**St MATTHEWS CATHOLIC COLLEGE, MUDGEES (SSD 9872)
CORNER BROADHEAD ROAD AND BRUCE ROAD, SPRING FLAT (MUDGEES)
RESPONSE TO SUBMISSIONS**

RESPONSE TO DPIE KEY ISSUES AND AGENCY, COUNCIL & PUBLIC SUBMISSIONS

Figure 3: AM Peak Traffic Flow Diagram

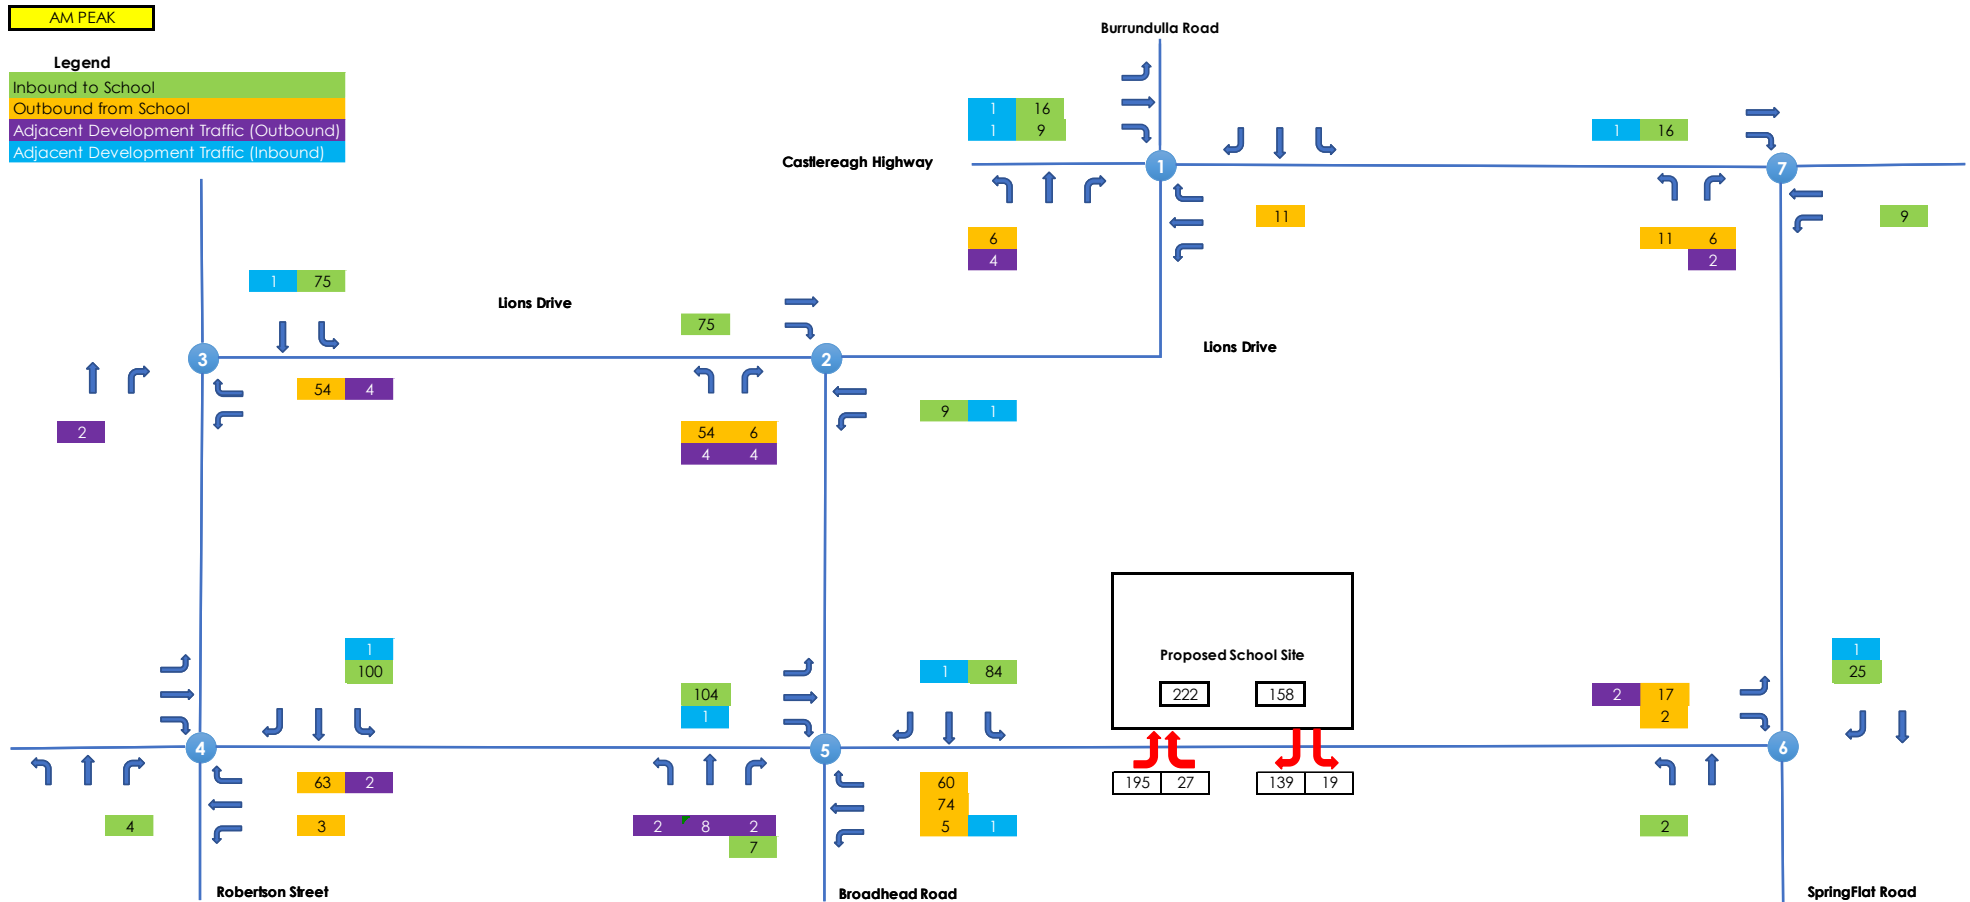
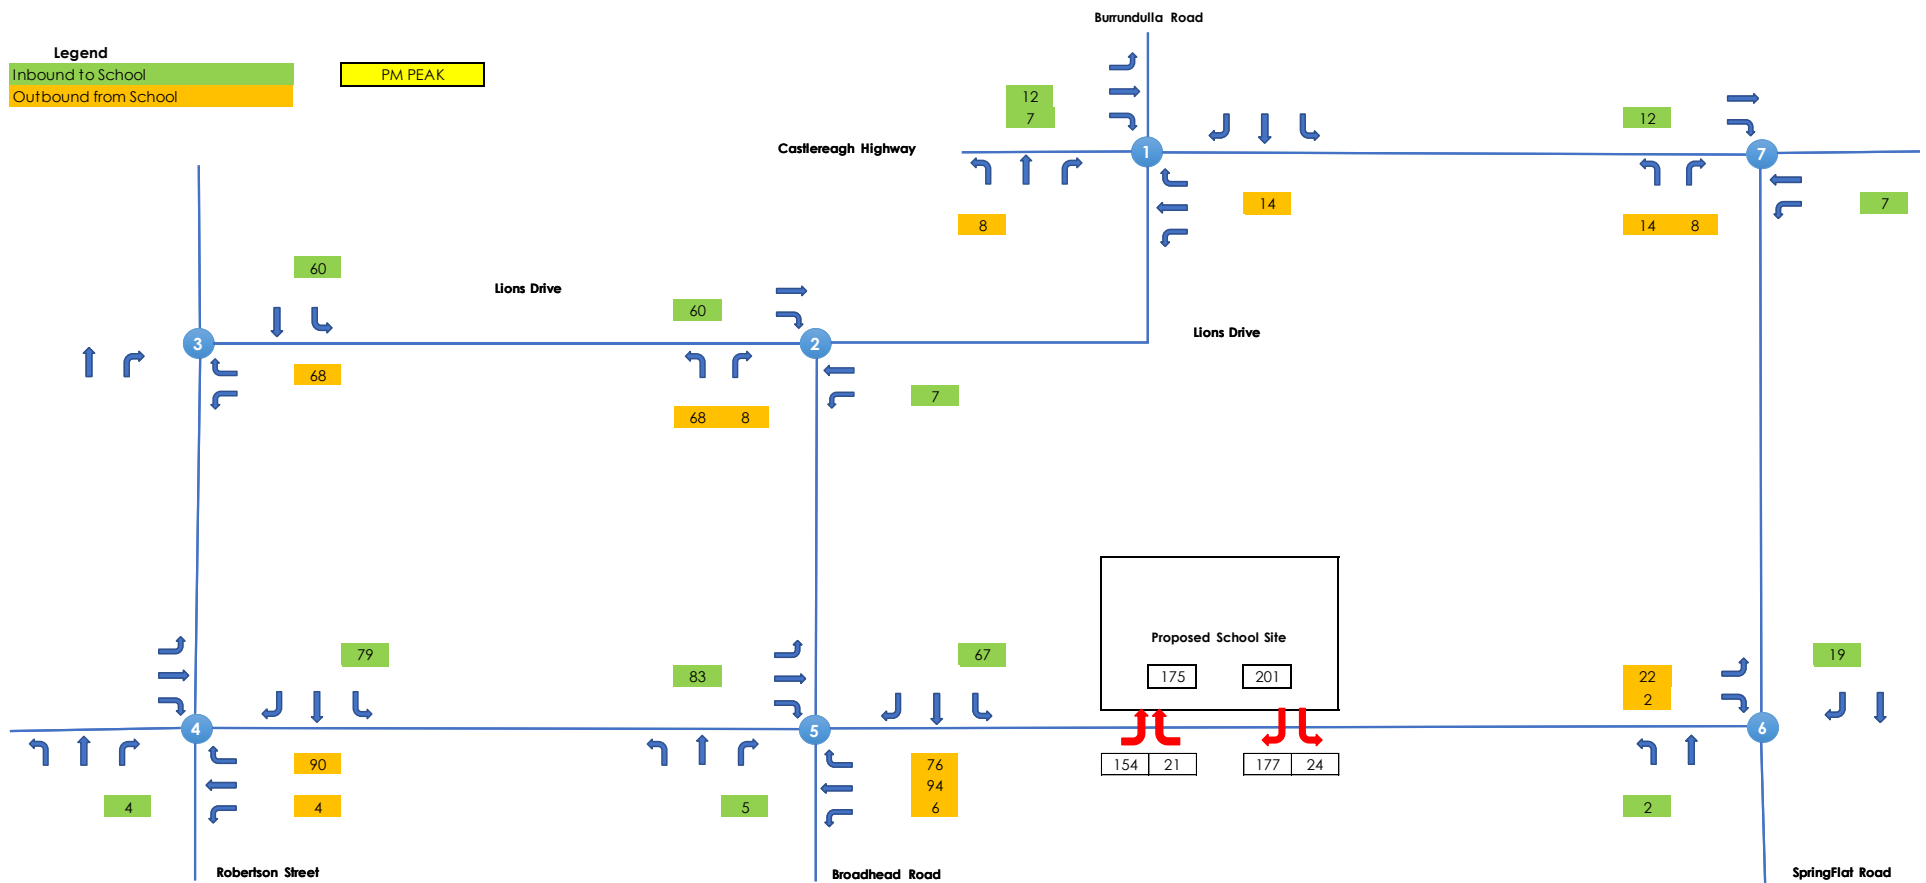
<p>(c) With the increased traffic from the eastern end of Bruce Road, the design of the intersection with the access driveways to the development is to ensure westbound through traffic on Bruce Road is not impacted. A SIDRA analysis should be prepared for the functioning of this intersection.</p>	<p>TTPP advises that under the revised traffic flow distribution as described above, the number of right-turn movements into the site during peak periods would be as follows:</p> <ul style="list-style-type: none"> • 27 westbound trips in the AM peak hour • 21 westbound trips in the PM peak hour. <p>SIDRA modelling results for the Bruce Road - site access intersection indicates that there would be a</p>

<p>no right-turn queue formed by the vehicles entering the site from Bruce Road east.</p> <p>The revised traffic flows are illustrated in Figure 4 and Figure 5 of the Traffic Statement – see Appendix B.</p> <p>It is noted that west-bound traffic on Bruce Road is presently minimal and would remain so under the developed school scenario.</p>
<p>(d) Further details are to be provided to demonstrate how the bus turning bay will function safely, particularly with the right turn out of the site and also considering the additional traffic accessing the site from the east.</p>	<p>Triaxial has confirmed the swept path and turning circle of buses leaving the bus bays to demonstrate a safe turning function. This is shown in drawings at Appendix H.</p> <p>Under the revised traffic flow distribution, school peak hourly trips on Bruce Road east would be:</p> <ul style="list-style-type: none"> • 27 westbound trips and 19 eastbound trips (total 46 two-way trips) in the AM peak hour • 21 westbound trips and 24 eastbound trips (total 45 two-way trips) in the PM peak hour. <p>This equates to one vehicle trip every few minutes which is a low traffic volume and would provide sufficient gaps in traffic flow on Bruce Road to permit buses turning out of the bus bay.</p> <p>The revised traffic flows are illustrated in Figure 4 and Figure 5 of the Traffic Statement – see Appendix B.</p>

DRAWING TITLE  
**FLOOD MITIGATION WORKS**

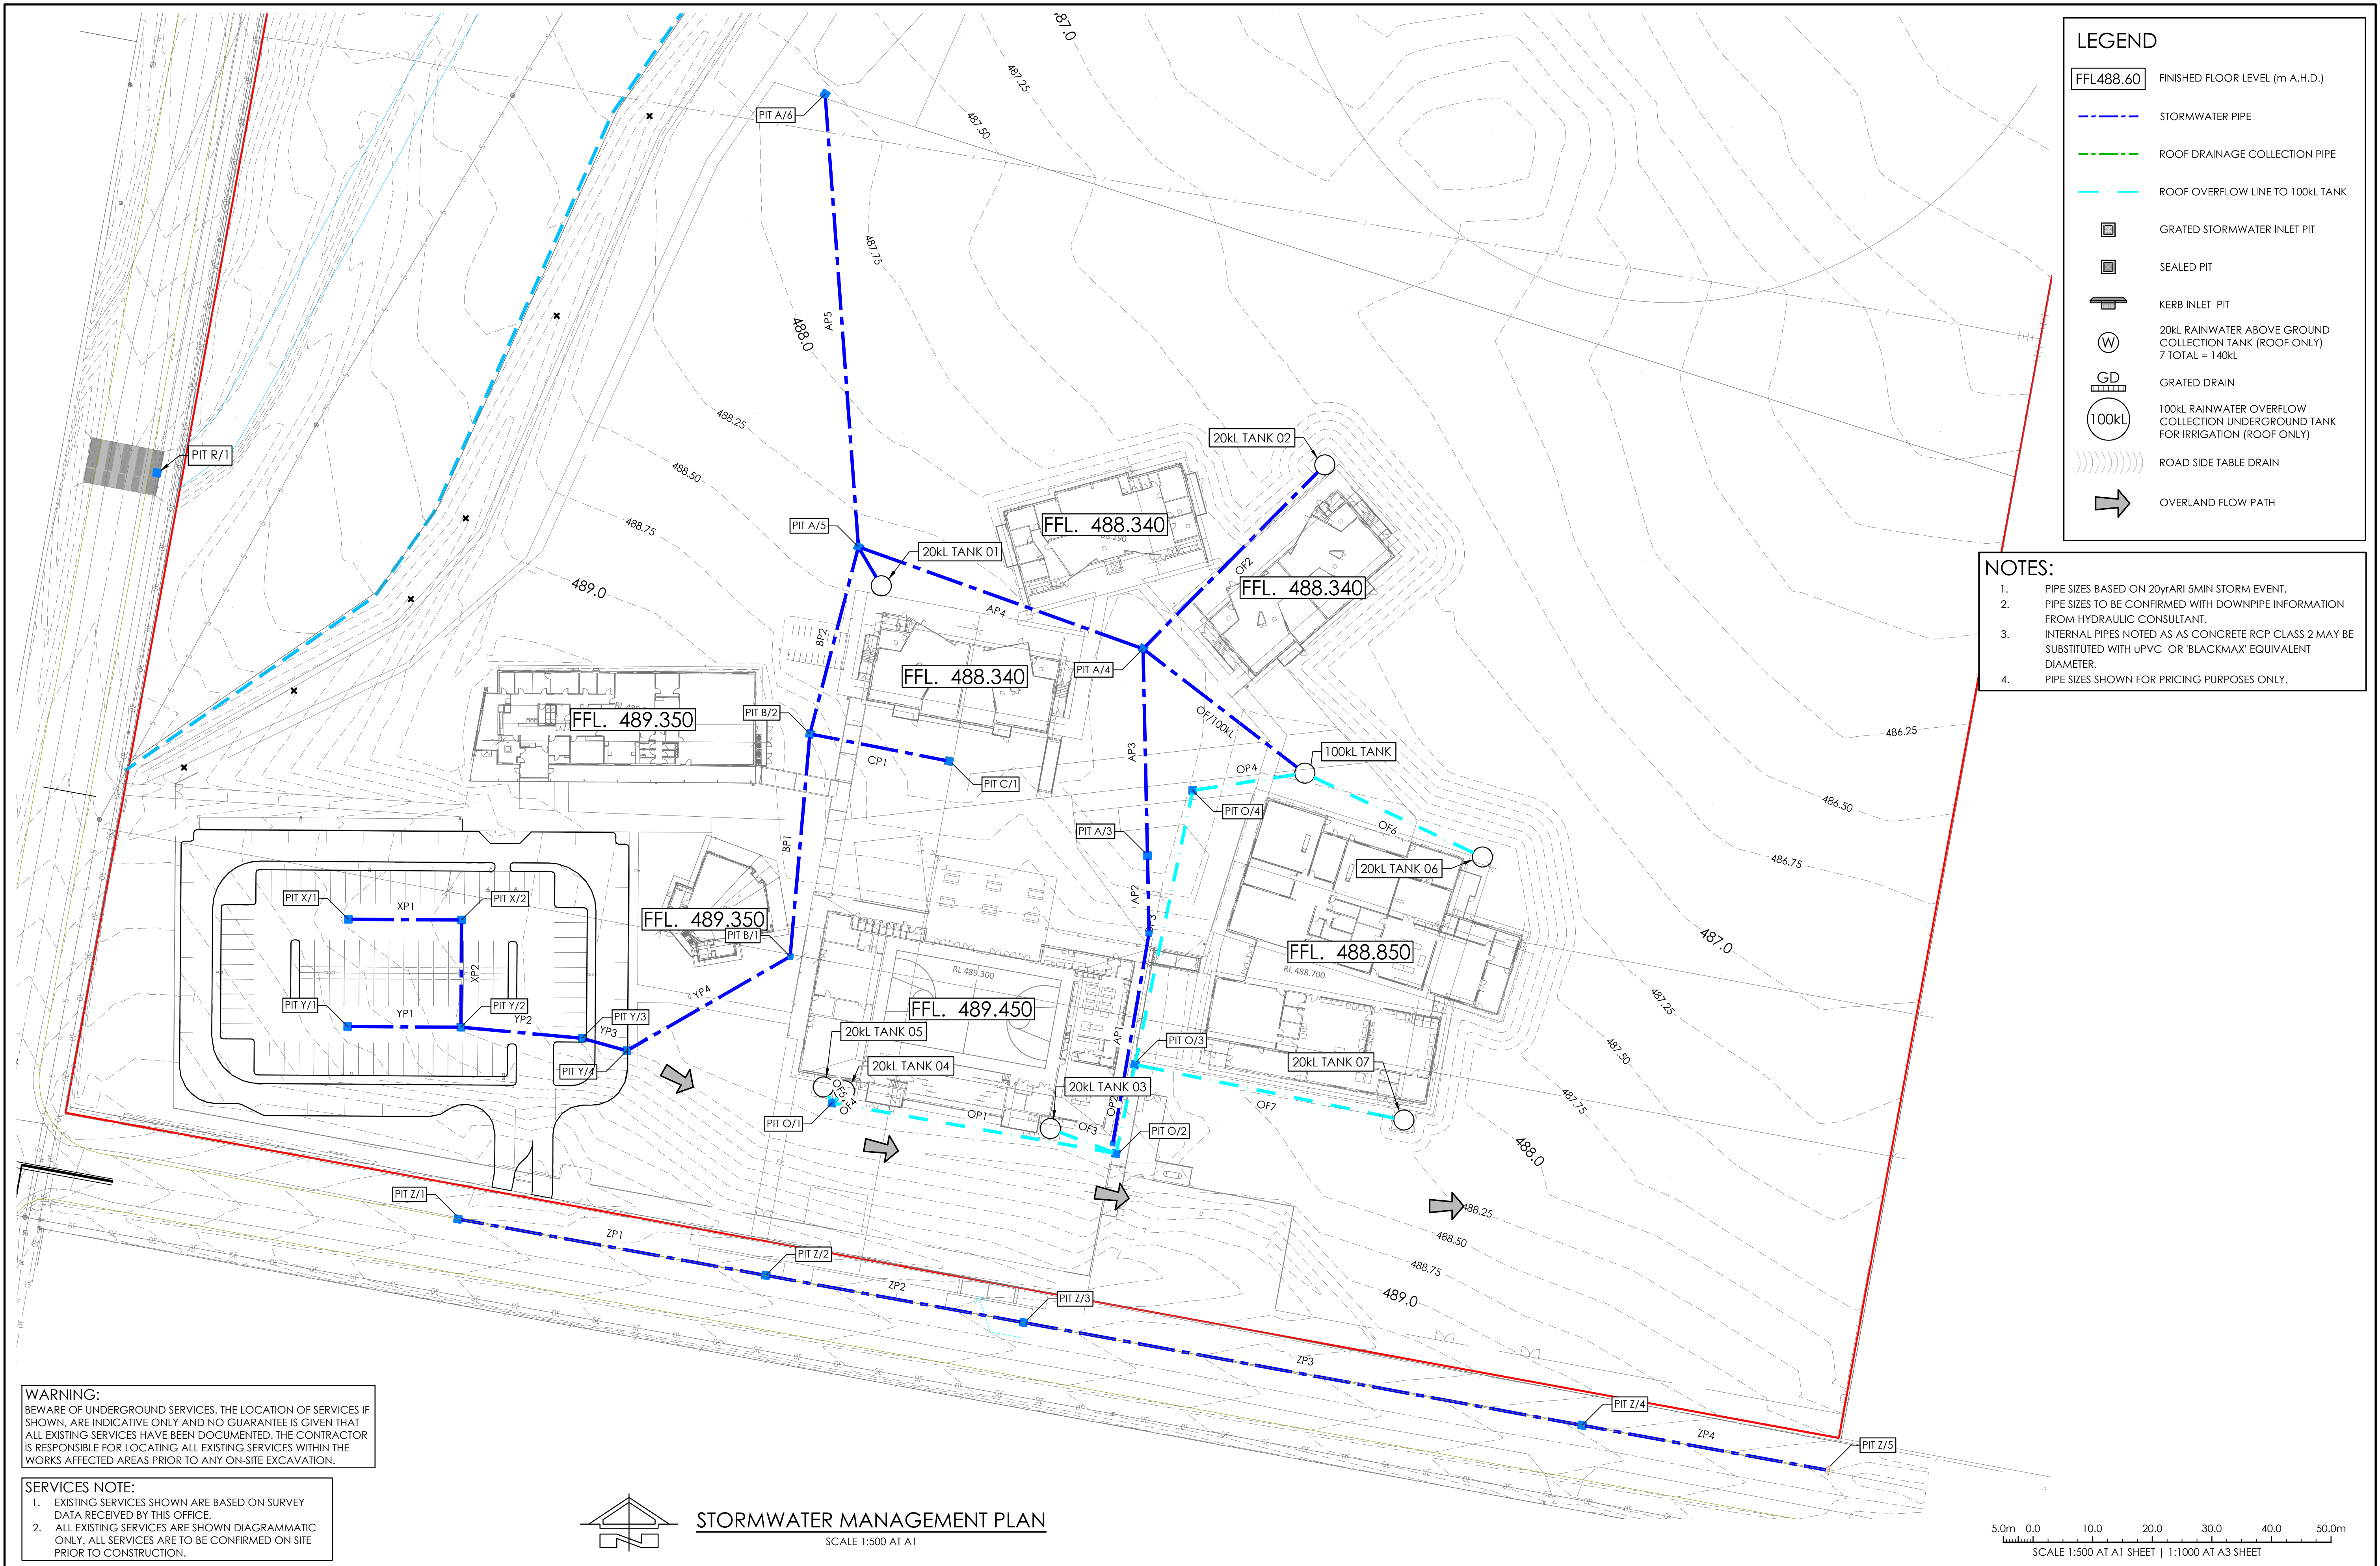
<p>The Department notes that Mid-Western Regional Council (Council) and Transport for NSW (TfNSW) have raised a number of concerns regarding the traffic assignments, relevant assumptions, parking and other traffic matters. The Department agrees with these concerns and considers that these be addressed in full in the Response to Submissions Report (RTS).</p>	<p>See further and more detailed commentary below and within other traffic-related documents as appended.</p>
<p>Drainage and Flooding</p>	
<p>The site is located within a natural catchment known as "Sawpit Gully" and is therefore impacted by a flood hazard. In accordance with Council's comment, a detailed Stormwater Drainage and Management Plan is to be submitted for the development.</p>	<p>Triaxial has prepared a revised Stormwater Drainage Management Plan arising from new but limited information recently provided by Council – See Appendix C.</p> <p>Triaxial have confirmed that Council has provided its current preliminary flood study. However, this study omits input flow rates which are necessary for modelling and to complete a detailed analysis. Notwithstanding, Triaxial has been able to remodel the flood scenarios at the site and environs through only moderately revised assumptions. It does confirm that the original assumptions and modelling were generally accurate based on the most contemporary and best available information at the time of the preparation of the report.</p> <p>The now revised Stormwater Drainage Management Plan still shows drainage as modelled and anticipated, however with only minor / insignificant levels of sheeting and waterflow over the roadways and which have now been further</p>

<p>addressed in the updated civil plans (stormwater and roadworks).</p> <p>Based on this low velocity sheeting of waterflow over Bruce Road, the project is required to include a graded and subtle landscaped earth berm (nominally 500mm high) to the Bruce Road frontage of the site to divert upstream water around the buildings. This will be integrated into the landscaping / topography to the extent that its existence will not be noticeable and appear as a continuous landscape feature at that frontage.</p> <p>To safeguard the development and assets, Triaxial has recommended the proposed buildings be raised by 150mm to ensure that there is no water ingress in a 1:100+ year storm event. Note, no building height control applies to the site and no new or material overshadowing arises.</p> <p>The revised Civil Engineering Plans and Architectural Plans addressing this change are included at Appendices G and H.</p>
